Application No:	H02-0189-23	Applicant:	Mr T Arlow
Proposal:	Proposed Dwelling (Plot 1) - outline approval H02-0564-22		
Location:	Plot 1 Adj. 17 Barbers Drove Crowland		
Terminal Date:	28th April 2023

CASE OFFICER ASSESSMENT

Drawing No. 22/631/PA/002

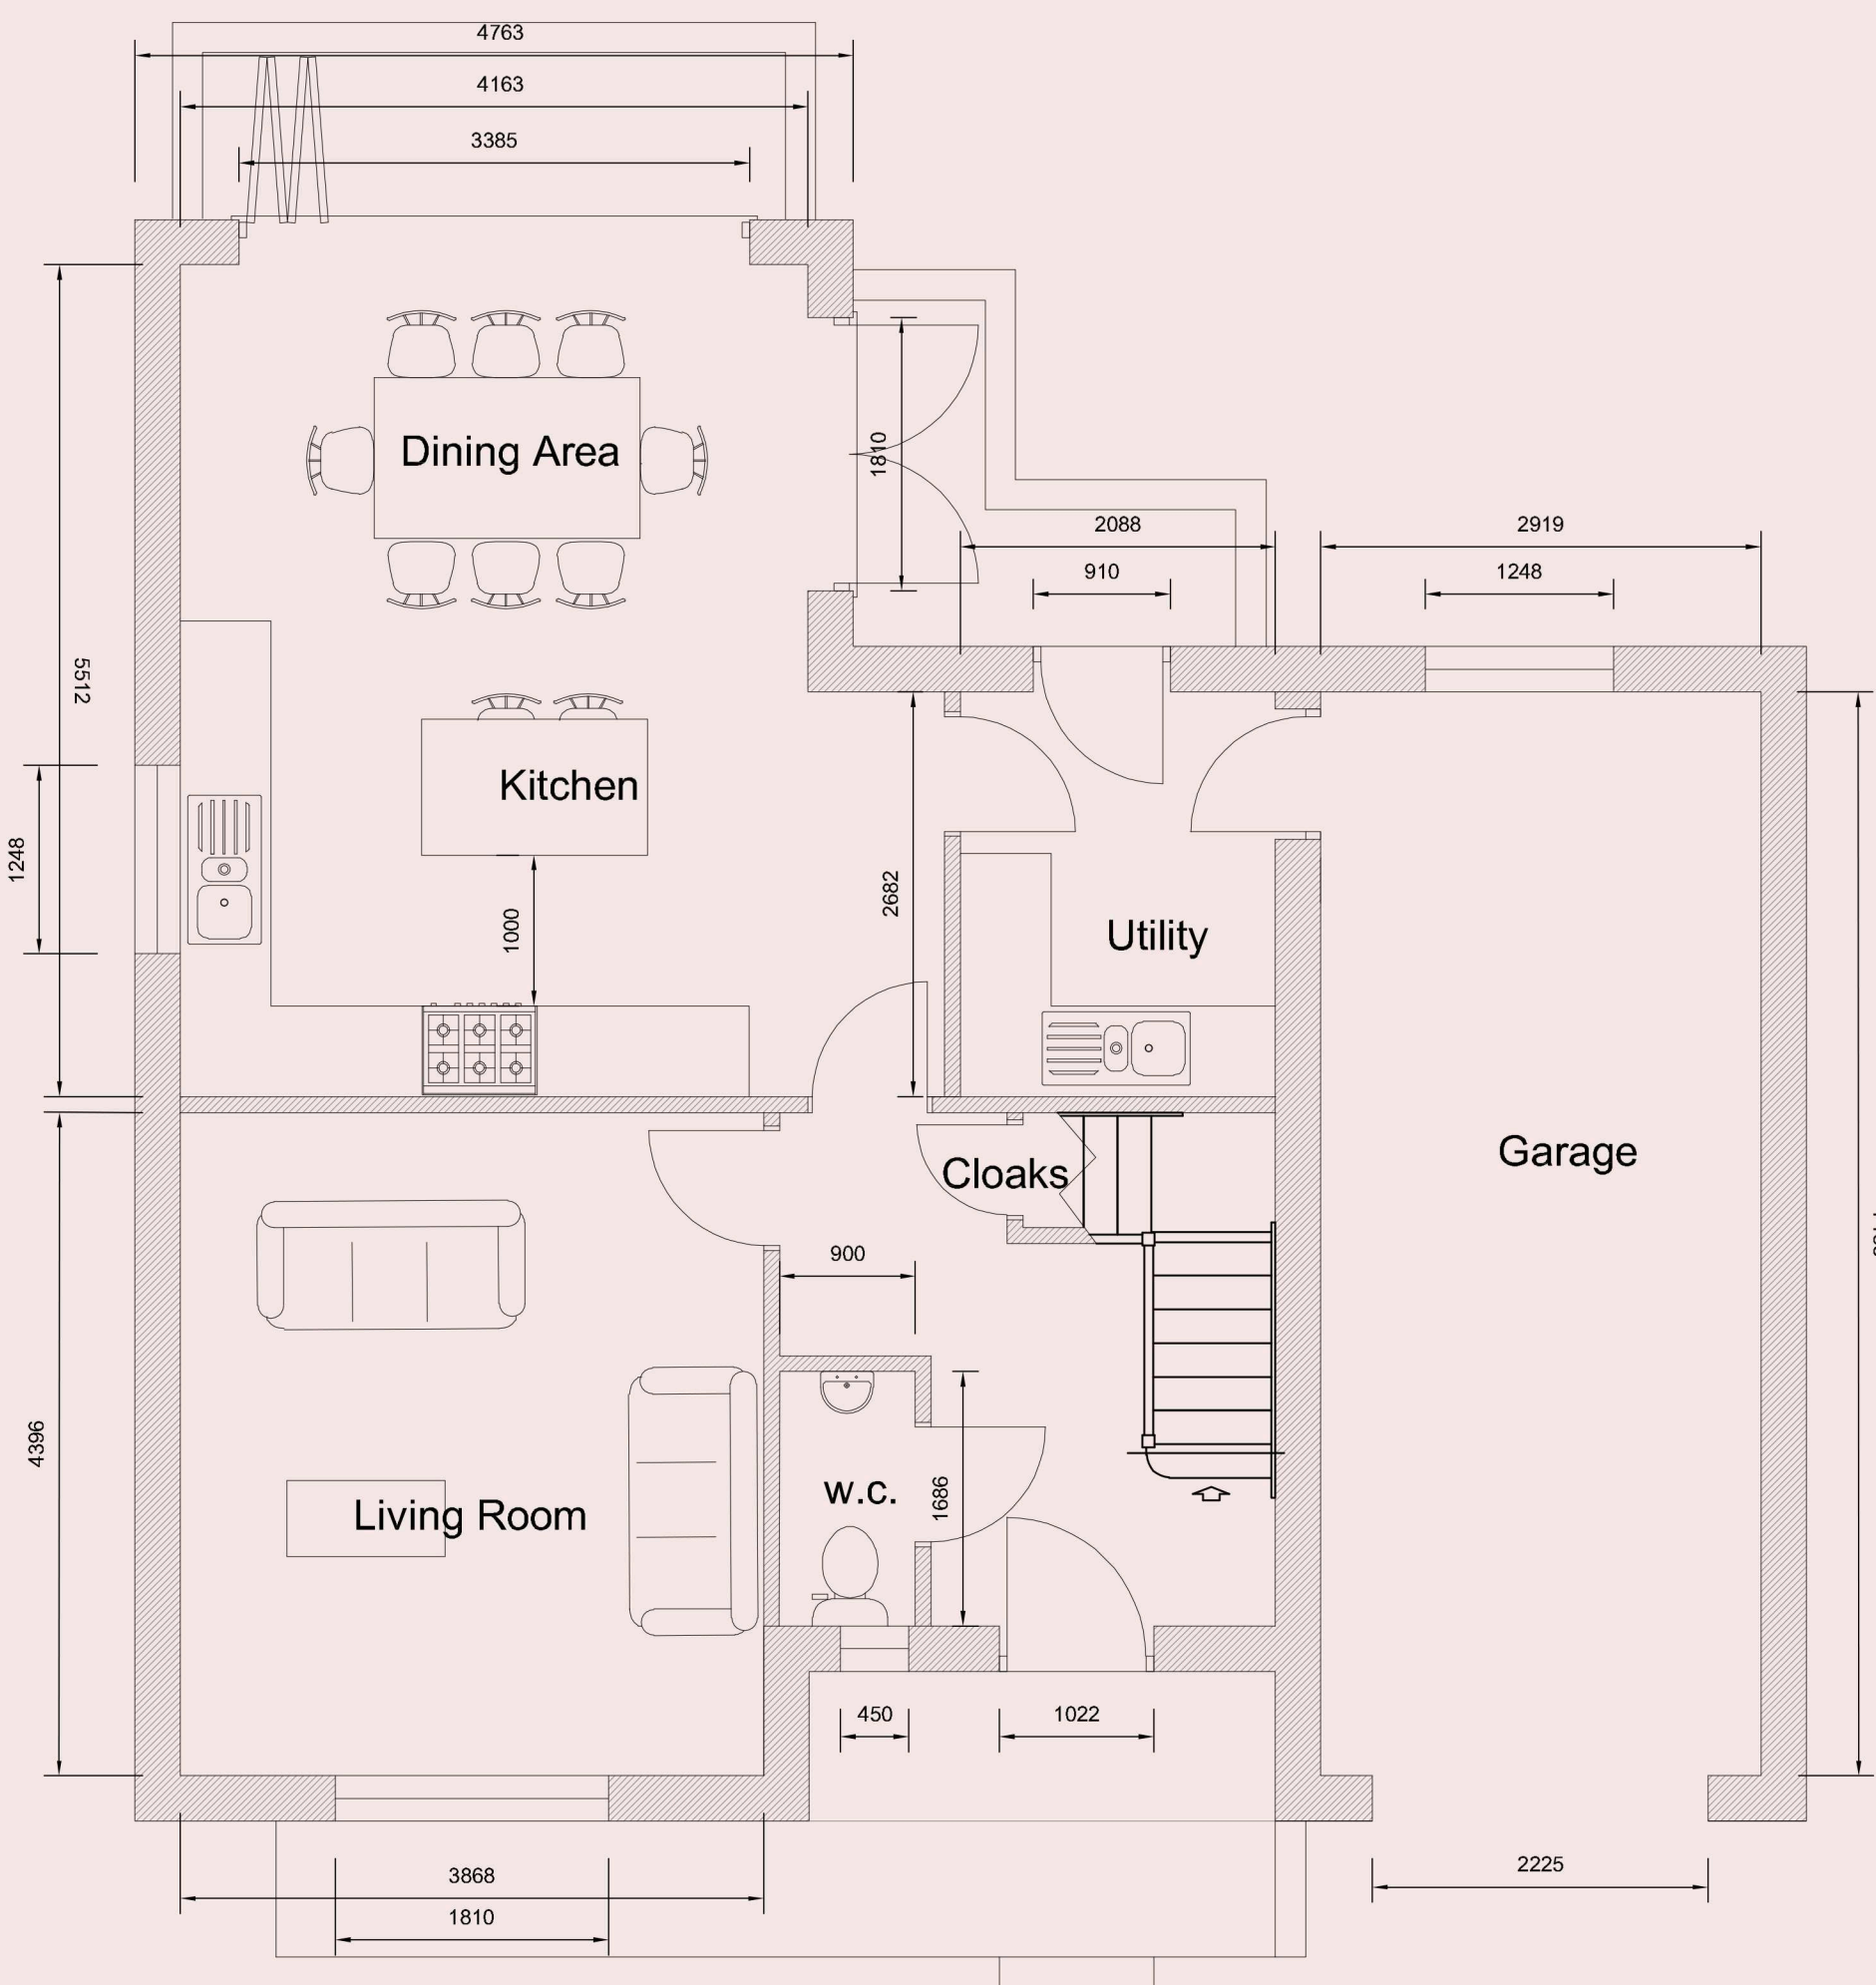
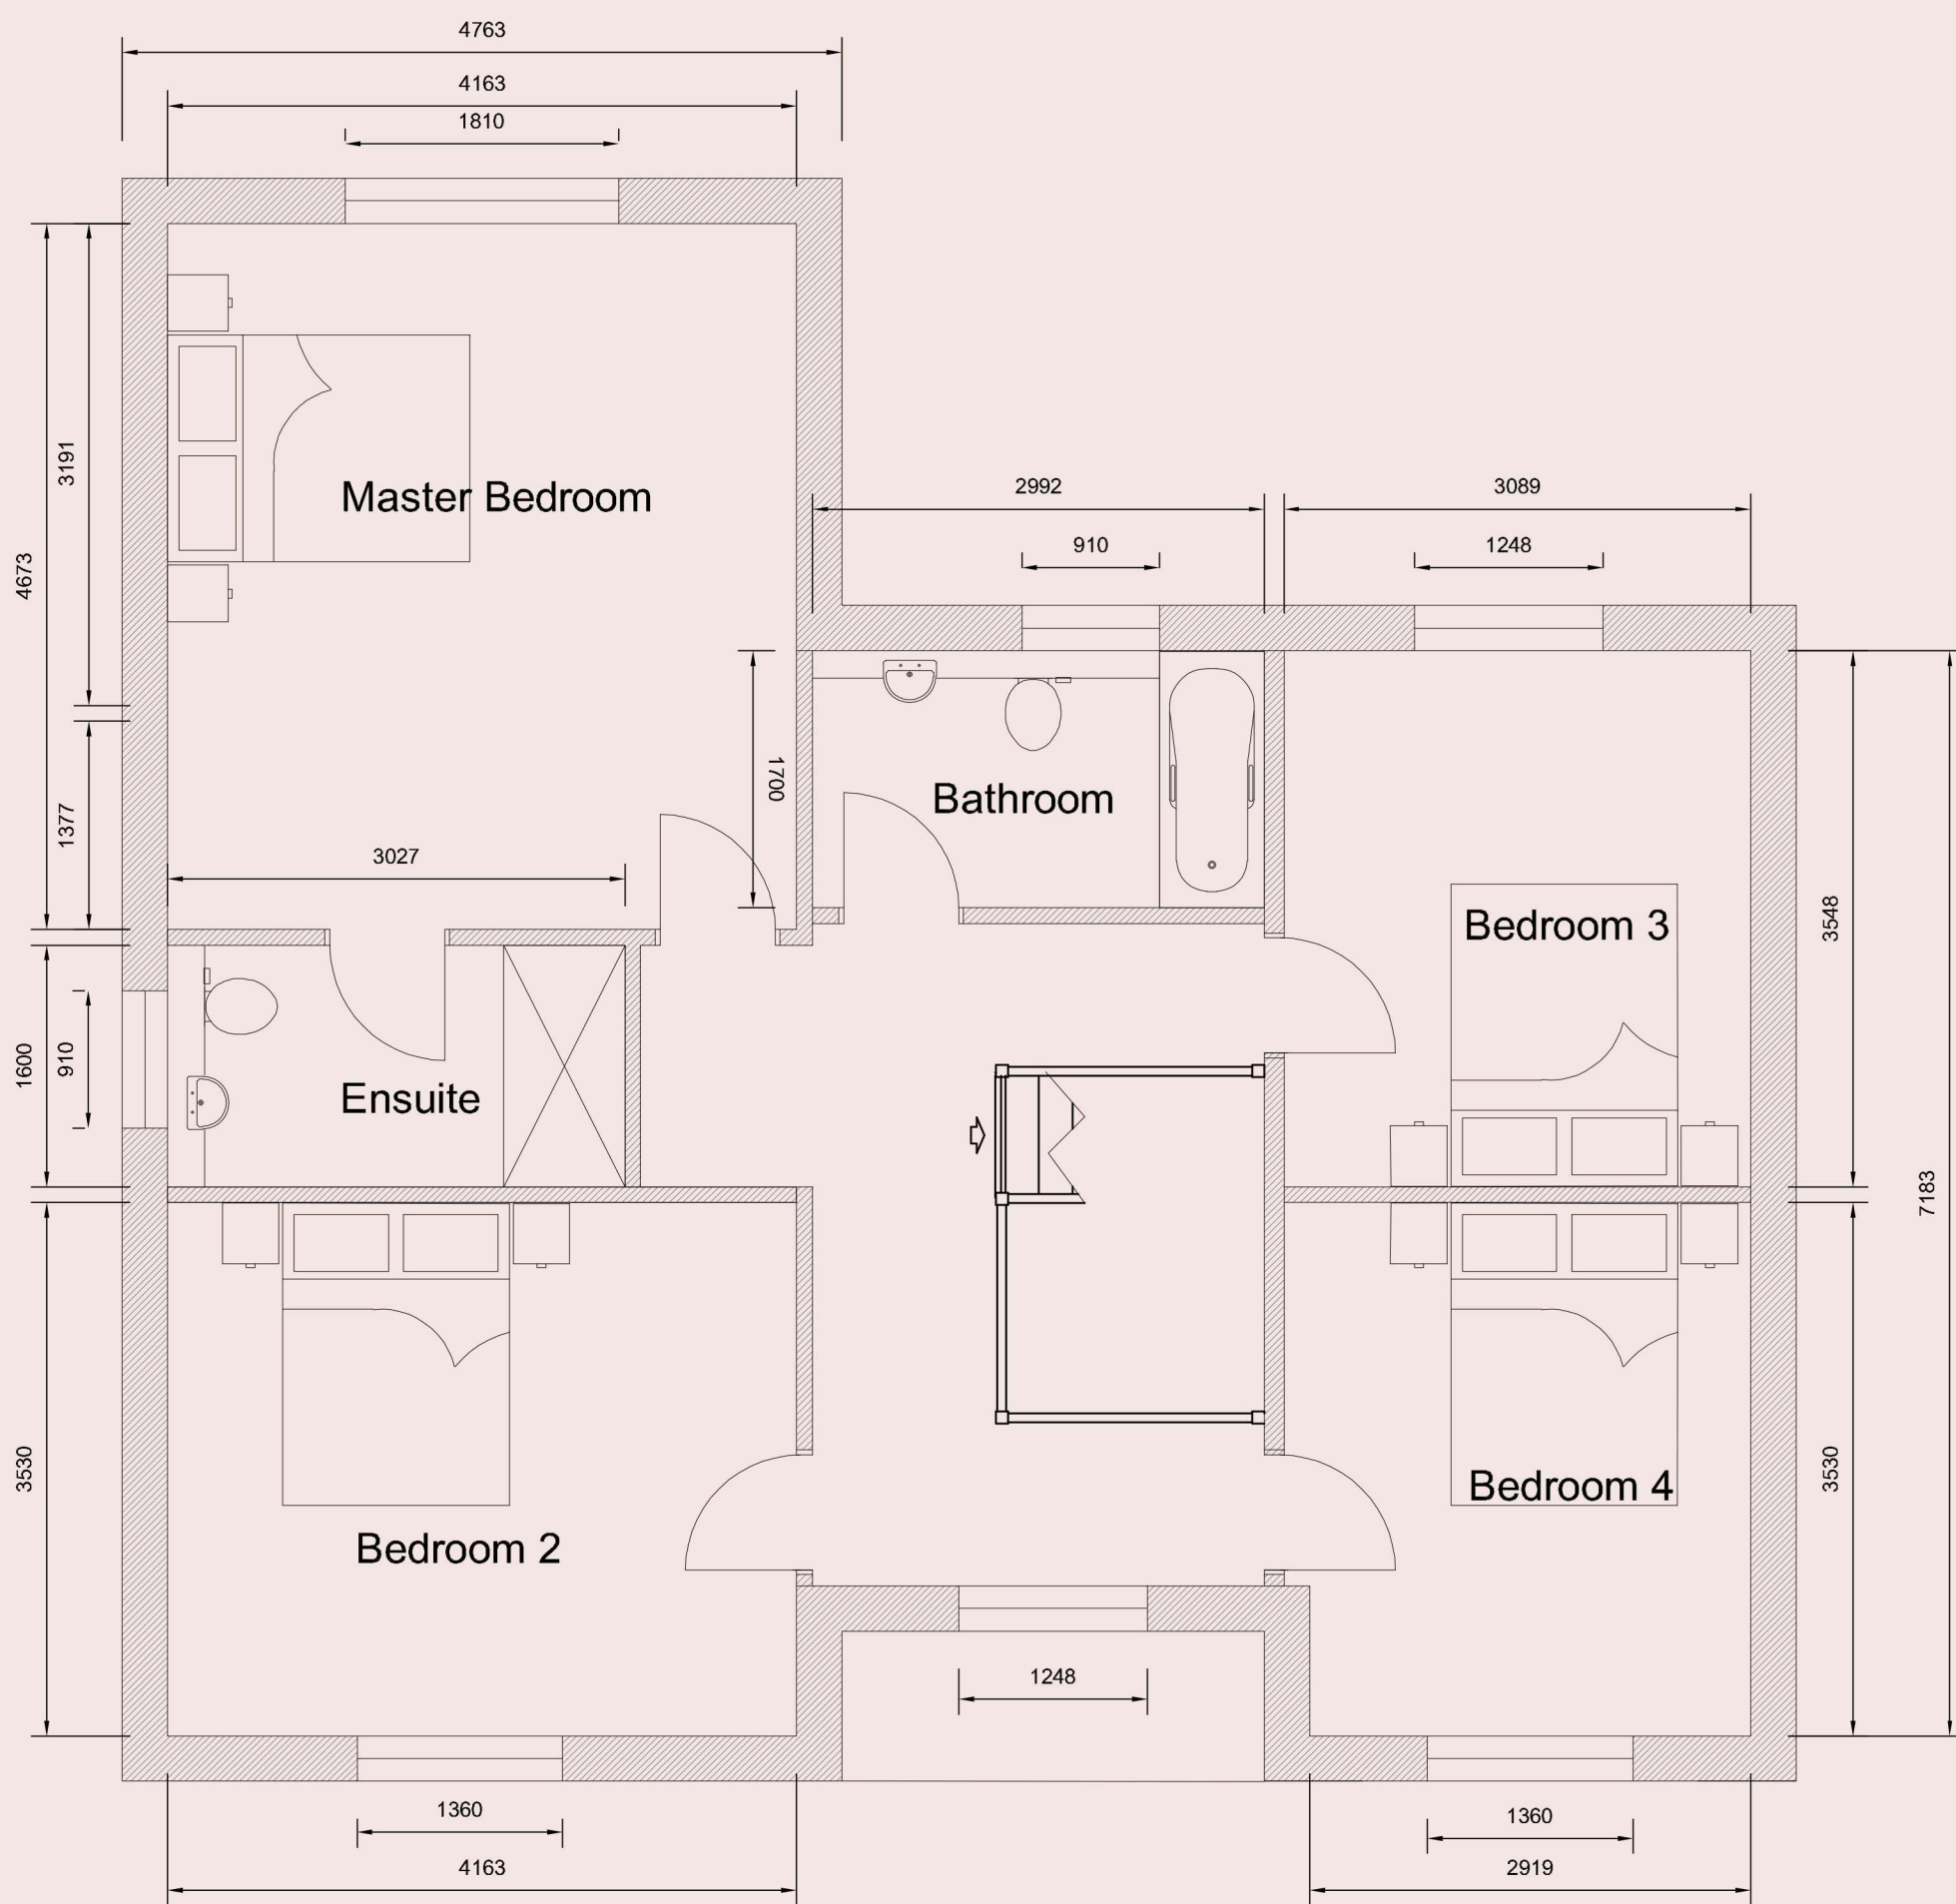
The block plan shows one dwelling sitting adjacent to number 15 Barbers Drove North, which is set north west of the application site. Number 15 has an access road to a garage adjacent to its boundary. Google Earth indicates the width of this access to be approximately 3 metres. An existing access road exists close to the boundary with number 15 (separated by grass at present) linking to 17 Barber's Drove North at the rear, which is being retained, but the access itself will need to be reconfigured for the redevelopment of the larger site behind. On the outline block plan for the 3 houses under reference H02-0563-22, the access to 17 Barber's Grove is shown almost directly next to number 15's flank boundary wall, with a further 3m access as required by H02-0064-21 adjacent to it. The flank wall of the application premises is set next to this required access. The proposed dwelling is set in 1m from the flank boundary of the plot.

The distance between the flank wall of number 15 Barbers Drove and the proposed dwelling is estimated to be approximately 11 metres (estimated to be 3 metres for number 15's drive to its garage; 4 metres for the reconfigured access for number 17; 3 metres for the required access as part of H02/0064/21 and a set in of 1 metre from the boundary of the application plot to the flank wall of the proposed dwelling). Given these distances, it is not considered that there would be loss of light, nor is it considered that the proposals would be overbearing on number 15. Whilst there would be a change to the view and outlook of number 15 from the 4 windows cited in the objection,

it is not considered that loss of view or outlook would be so severe as to justify refusal due to the separation distances mentioned above. However, in order to protect privacy a condition is suggested restricting further flank windows or other openings on the dwelling, and to ensure the first floor flank window is finished and maintained in obscured glass.

Two gables form the main feature of the front elevation, with finished floor levels set to 2.3 OD. Site levels are to be raised very slightly from existing ground level to match the road which is 1.82 OD. The design incorporates a rear projecting gable with indian slate patio and rear garden laid to lawn and landscaping. The rear garden is between 7.5 and 10 metres which is considered satisfactory for a modern development.

The dwelling would be approximately 8.3m to the top of the ridge, 7.3m to the top of the largest gable, 5.3m to the top of the eaves and 11m wide. The flank of the proposed dwelling would be approximately 11m from the flank wall of number 15 Barbers Drove when measured on the Block Plan.

However, the storey height on this plot was not restricted to bungalows in the outline consent, the layout does allow a small set in of one metre each side, and whilst set forward of number 15, there is an estimated separation distance of 11 metres from this property and the application property, and the proposed dwelling has a 7.4m driveway, setting it back from the road. These factors will reduce its prominence. It is not considered that refusal of planning permission due to its impact upon the street scene would be justified. The scale is not considered to adversely affect the street scene to such an extent that it would be contrary to policies 2 and 3 of the SELLP.
